Mr Brent Lawson
The Trustee for Minto Property Trust
PO Box 7108
Silverwater New South Wales 2128
26 November 2020

**Minto Resource Recovery Facility (SSD-5339)
Response to Submissions**

ATTACHMENT 1

WORKSHOP SHED

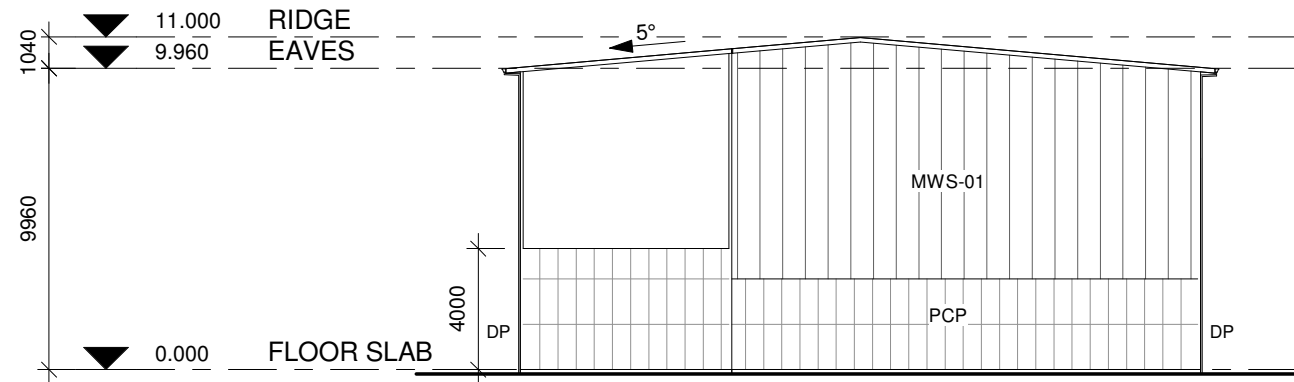
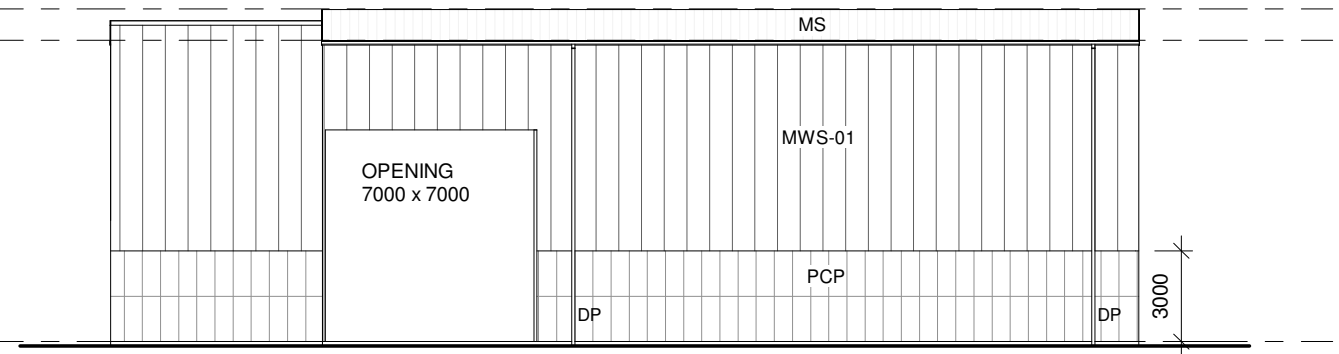
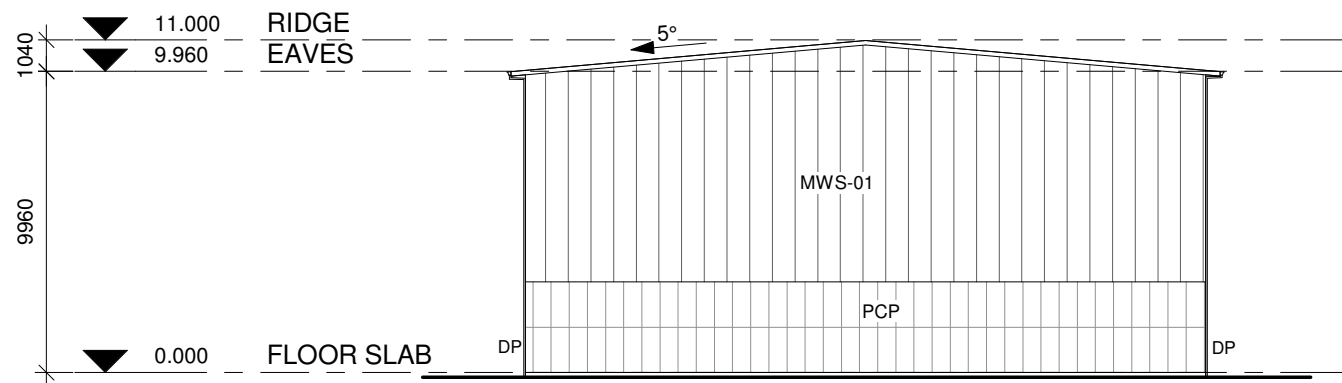
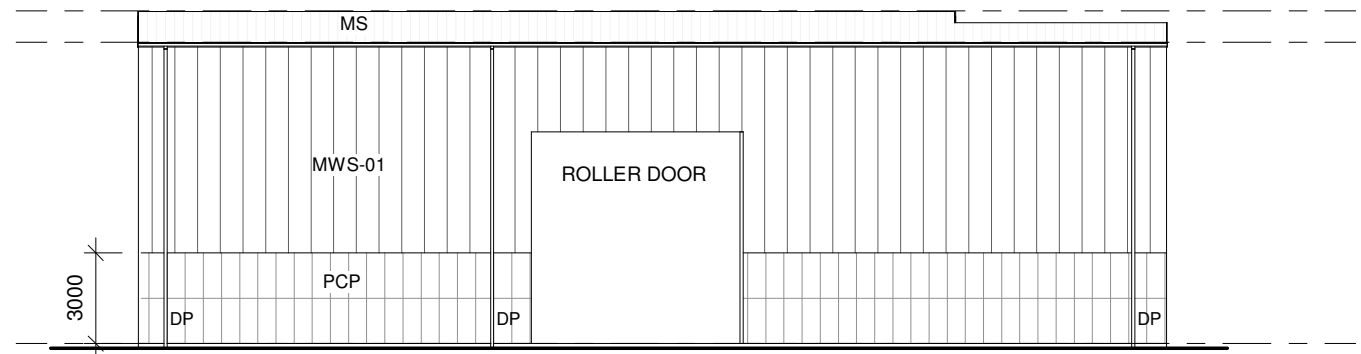
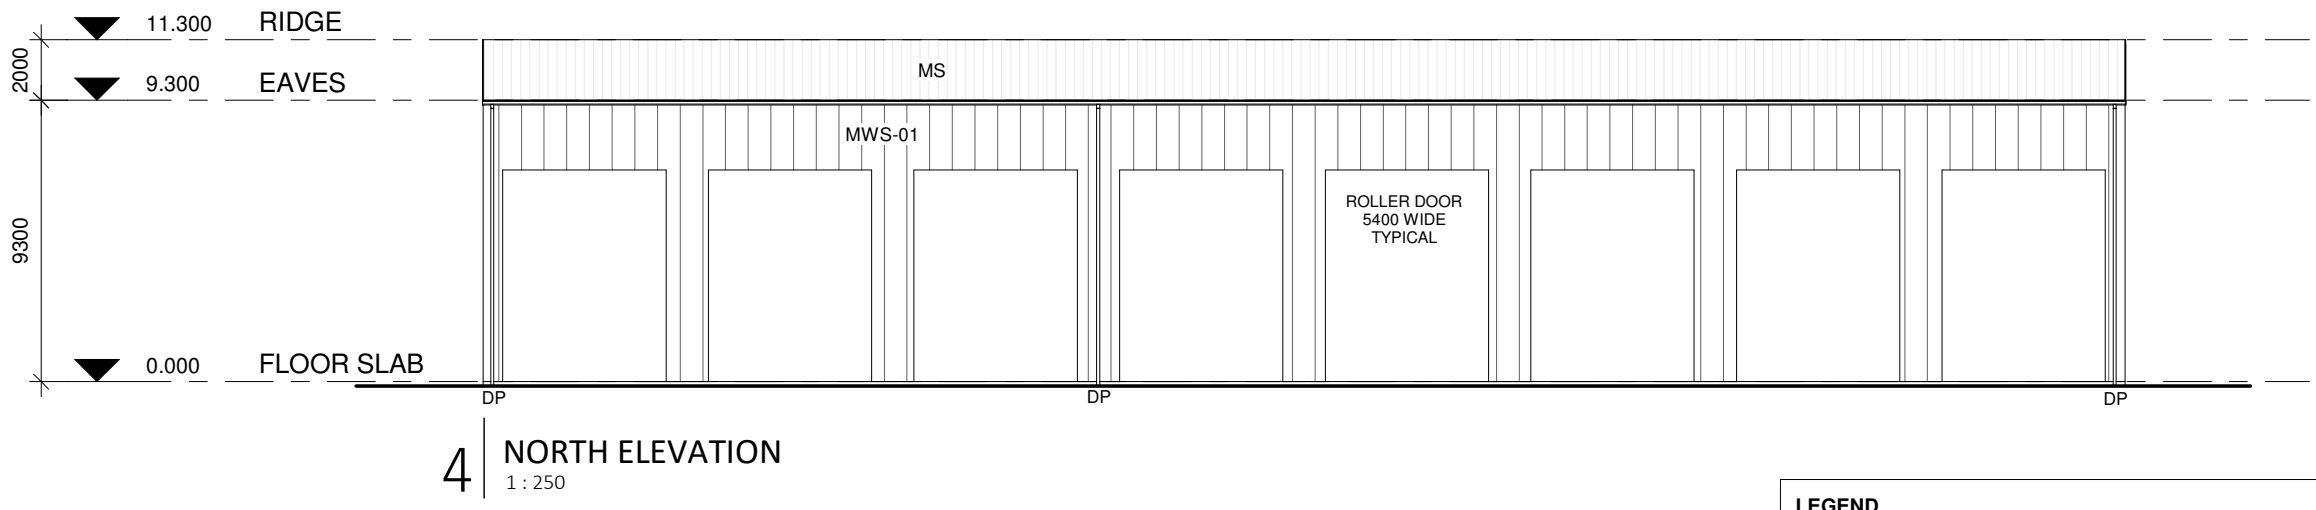
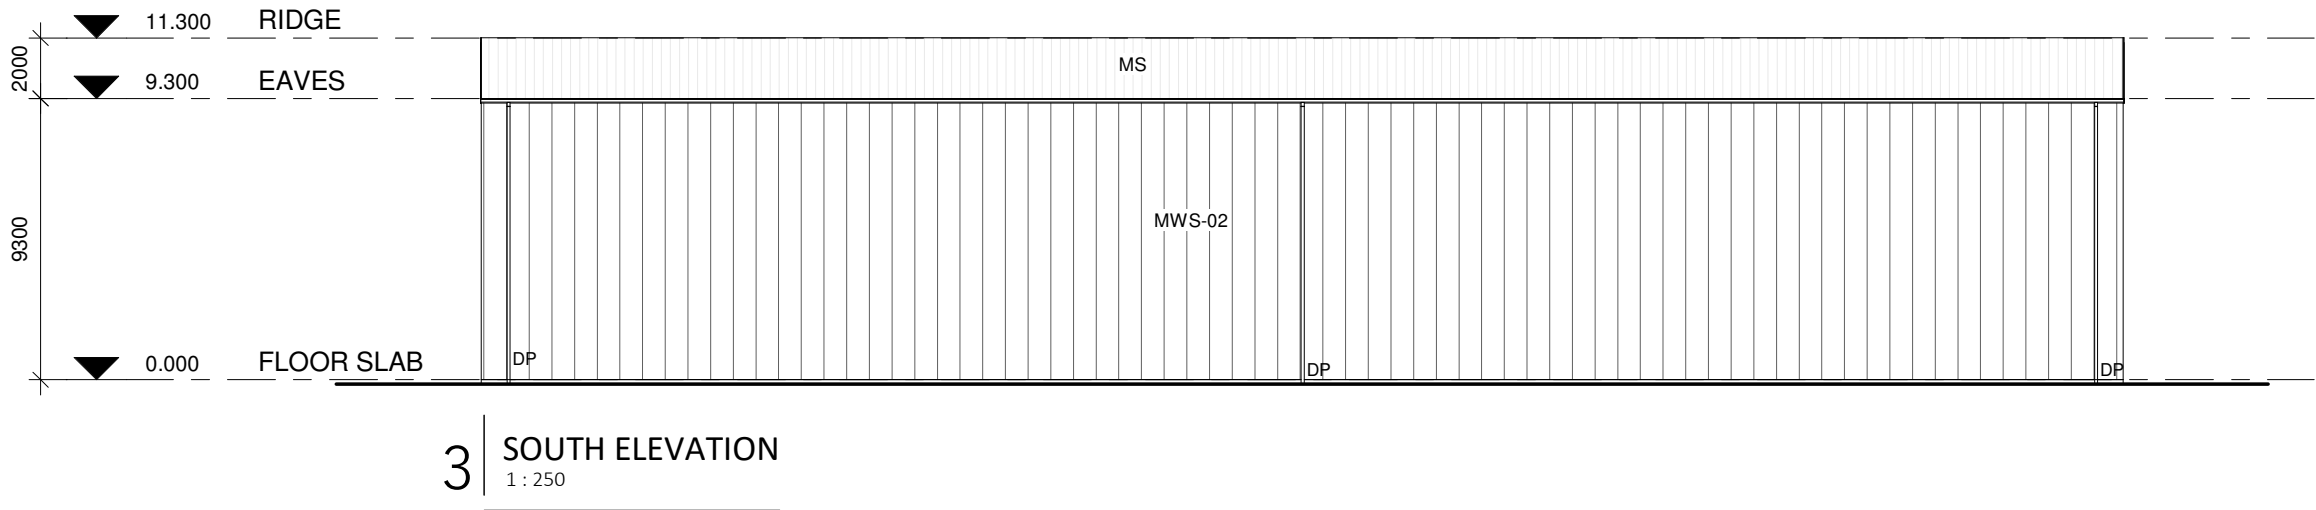
- Provide architectural drawings including elevations of the workshop, sand shed and any other permanent structure on site.
- Please label the tip and spread area on a plan to demonstrate that it will be separated from the larger waste stockpiles and that its size will be sufficient to meet the requirements of the EPA's *Standards for Managing Construction Waste*.
